Project# 1008437

10DRB-70339 VACATION OF PUBLIC RIGHT-OF-WAY

**CITY OF ALBUQUERQUE
PLANNING DEPARTMENT
September 22, 2010
DRB Comments**

RE: Lot 83, Alvarado Gardens Unit 3

SKETCH
LOT 83-A
ALVARADO GARDENS
UNIT 3
 ALBUQUERQUE, BERNALILLO COUNTY, NEW MEXICO
 DECEMBER, 2010

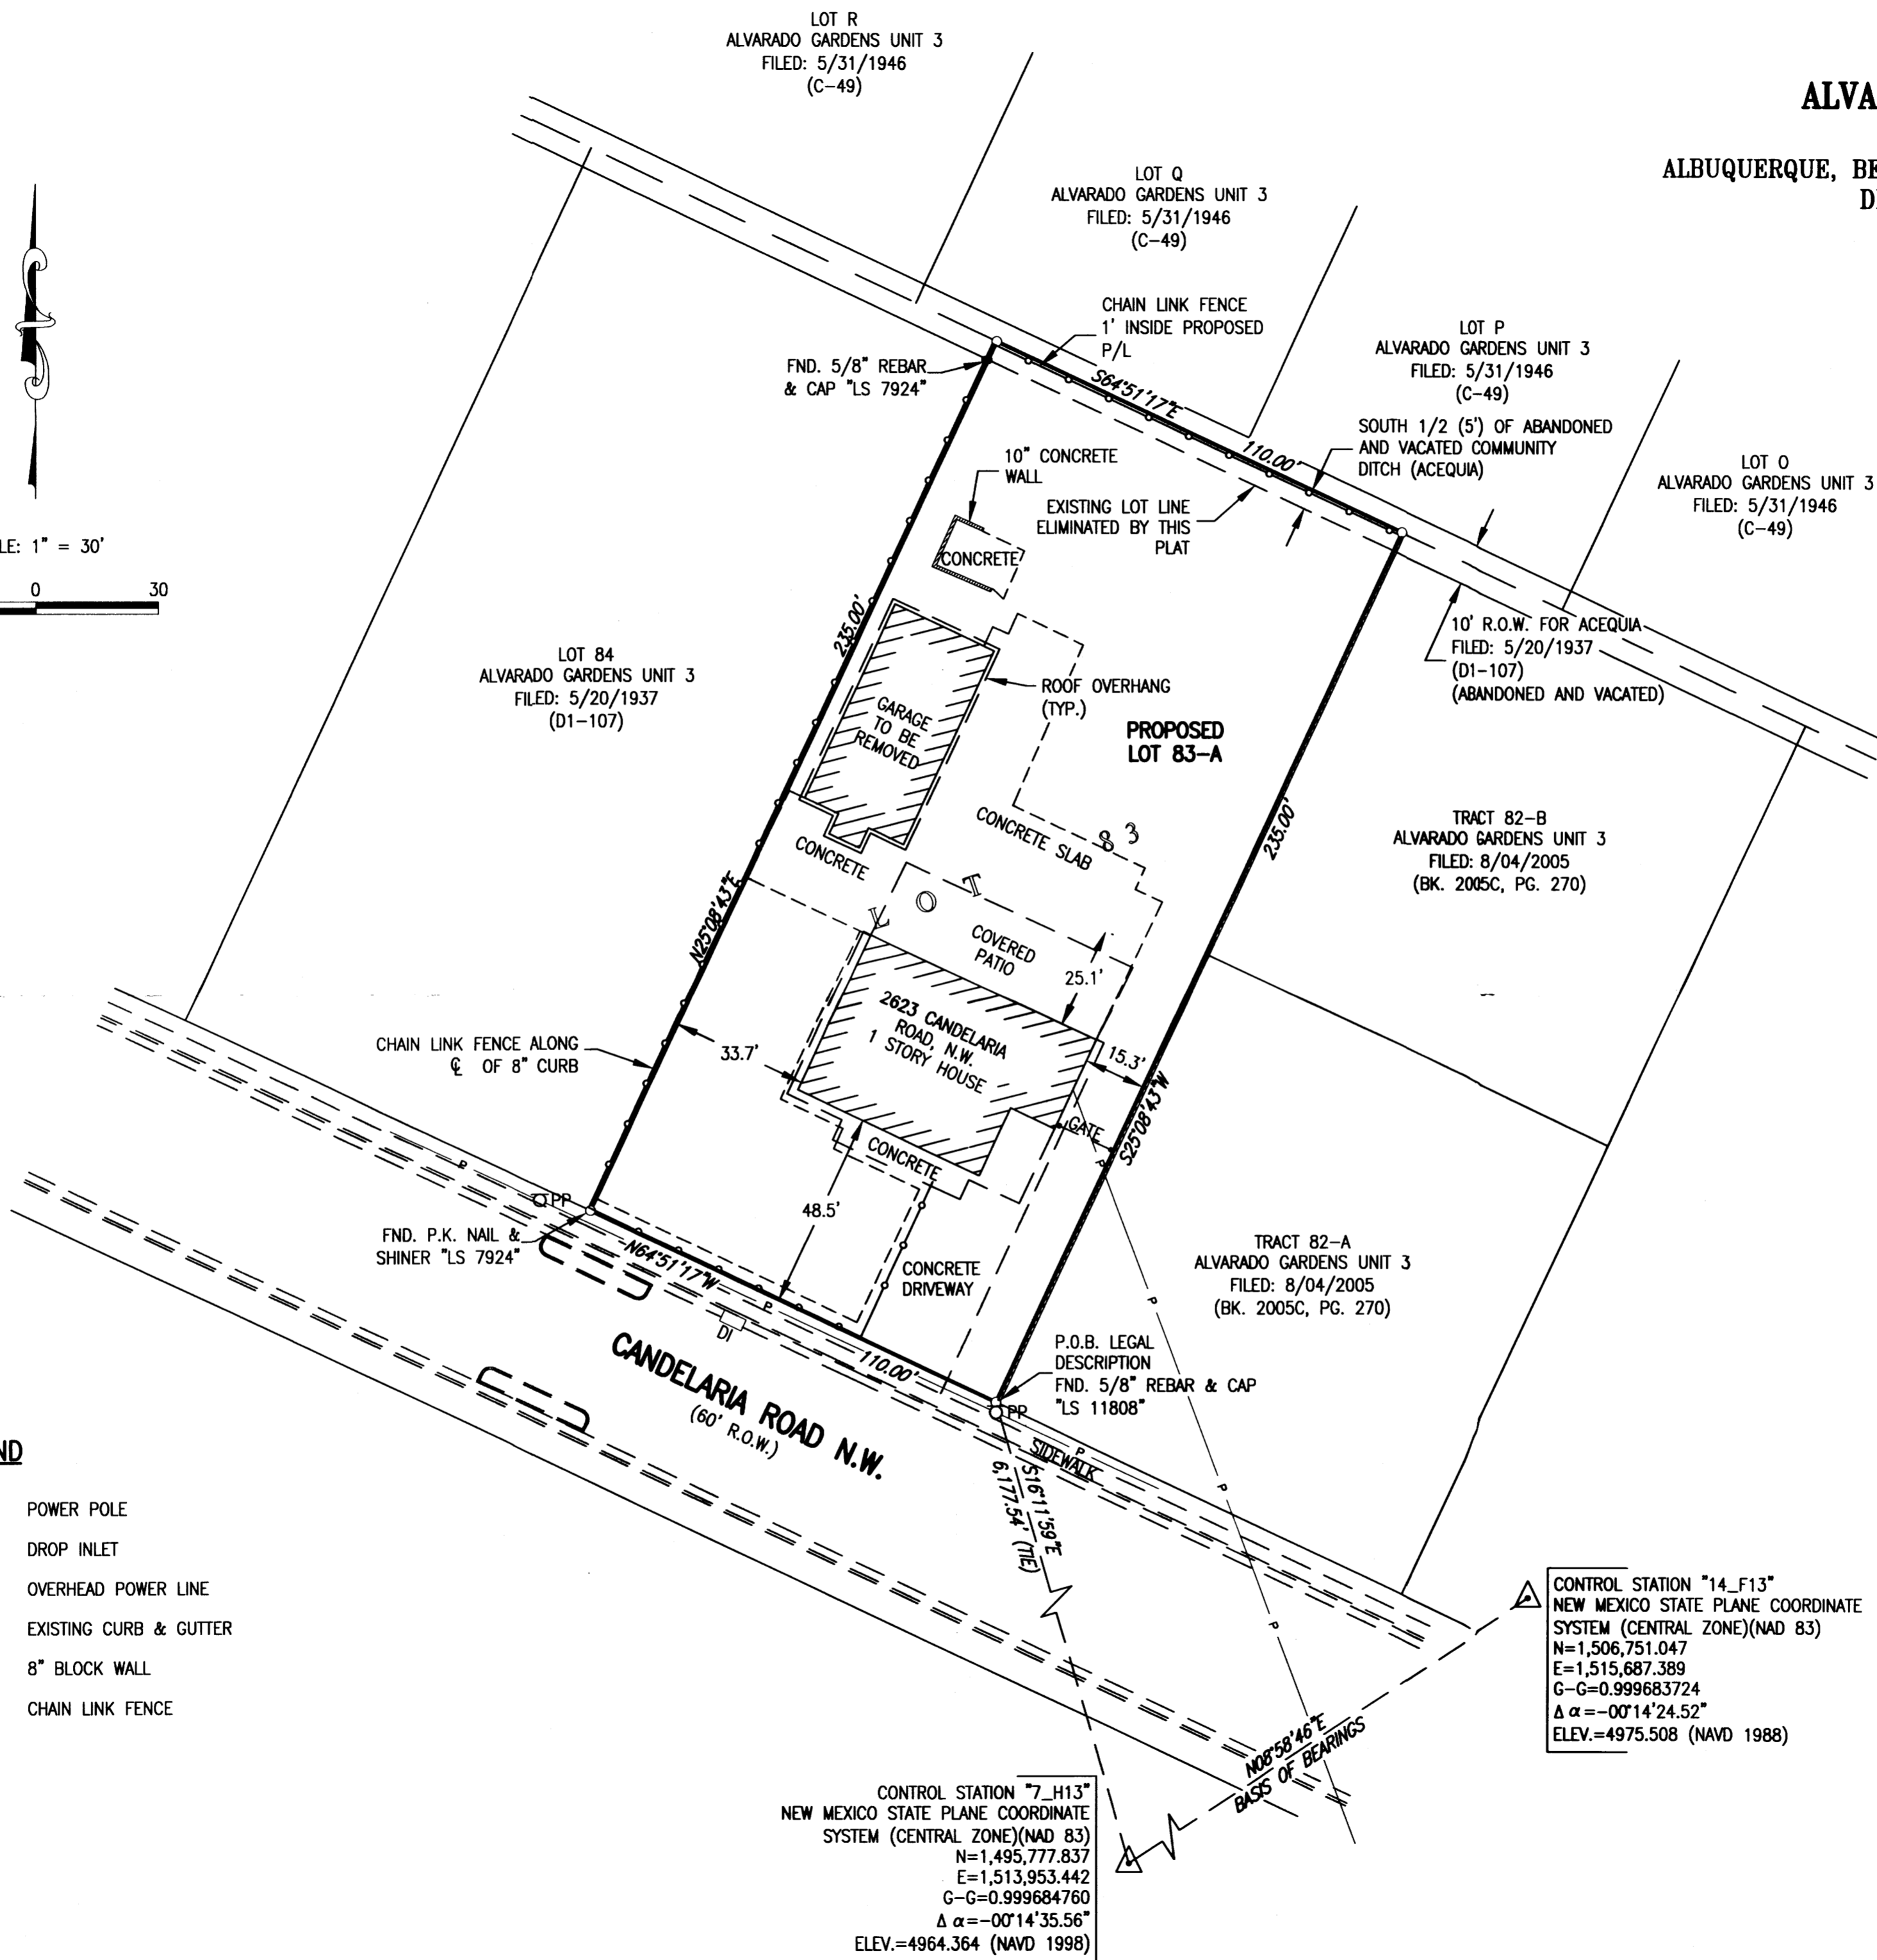
Provide an exhibit showing the location of sidewalk and defining the distance from face of curb to the property line. Right of way dedication may be required.

**PLAT OF
LOT 83
ALVARADO GARDENS
UNIT 3
ALBUQUERQUE, BERNALILLO COUNTY, NEW MEXICO
DECEMBER, 2010**

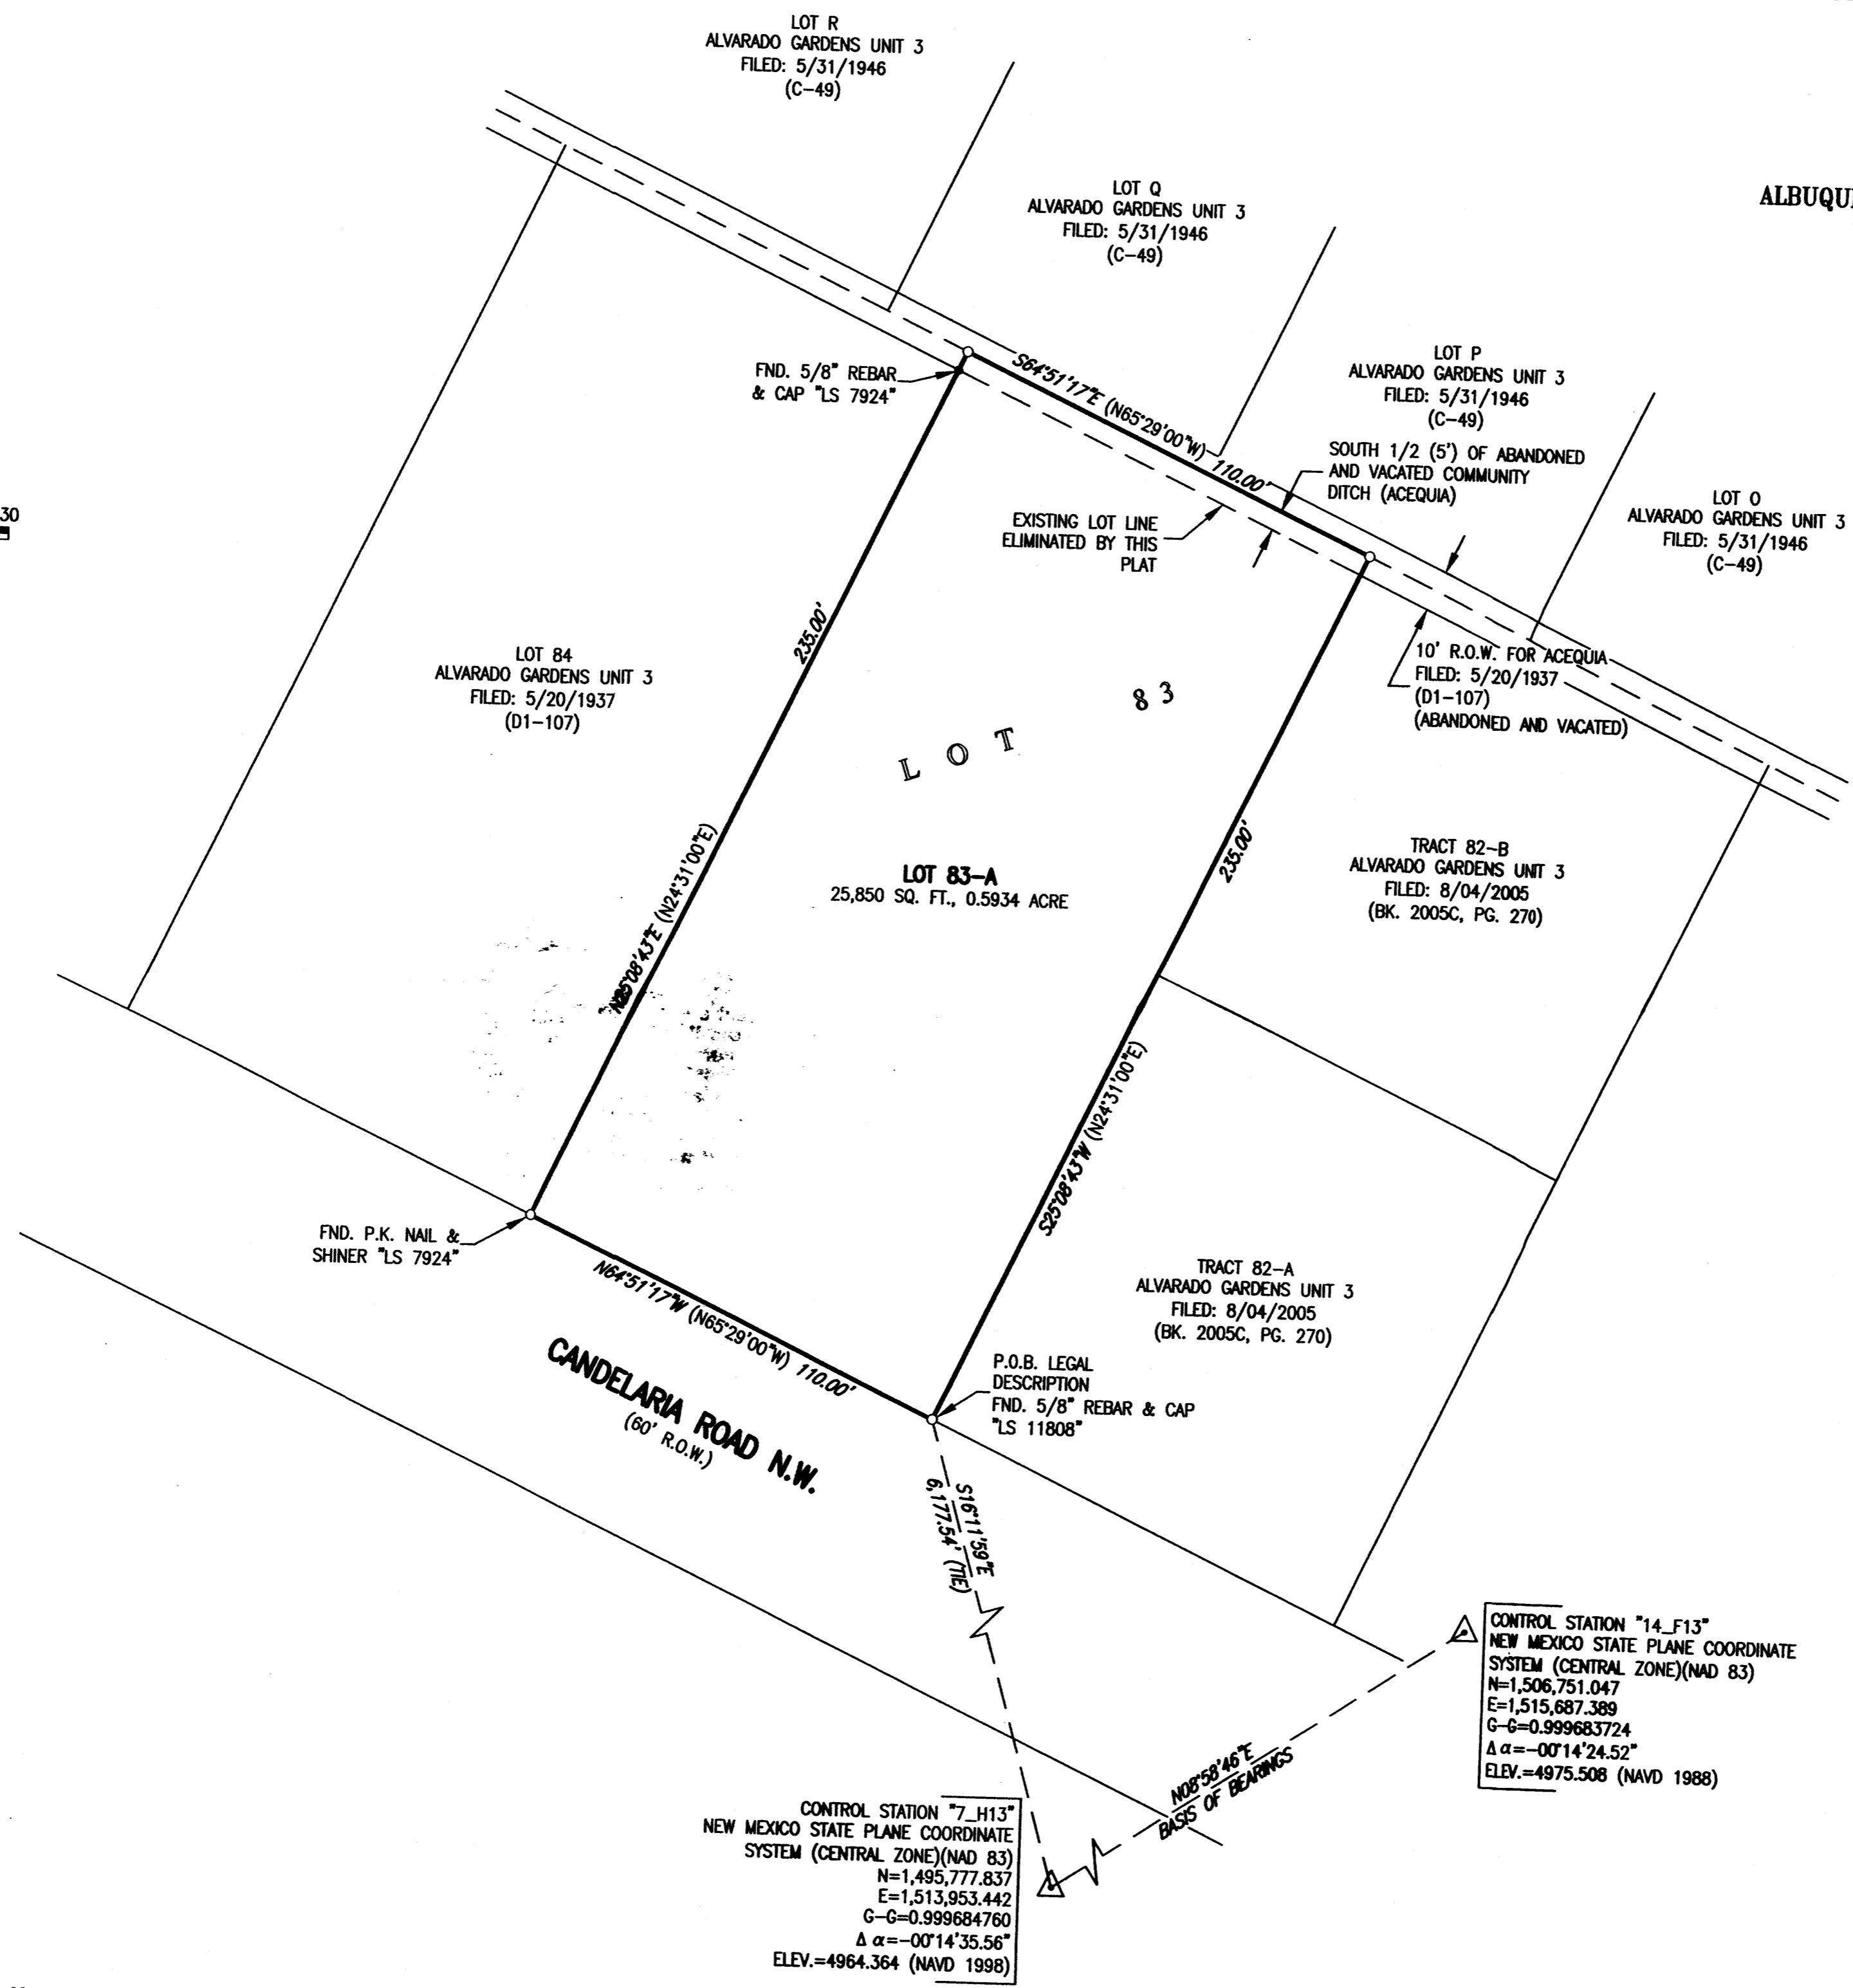
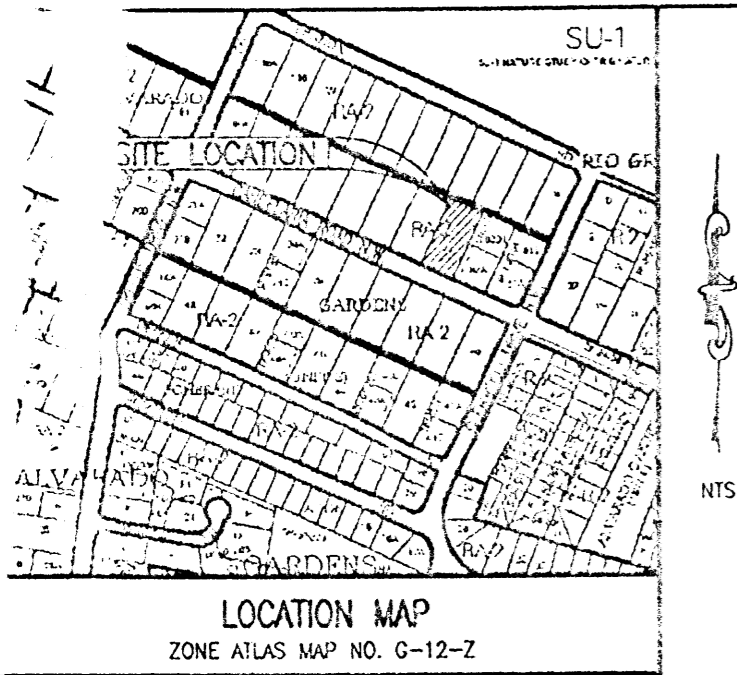
Vacation of Acequia would need to be documented and referenced on the plat – it appears a separate Vacation request will be required prior to or concurrent with plat action.

A Solar Note consistent with § 14-14-4-7 of the Subdivision Ordinance is required. Also, for future reference please remove “ZONING” (Note 7) from SUBDIVISION DATA.
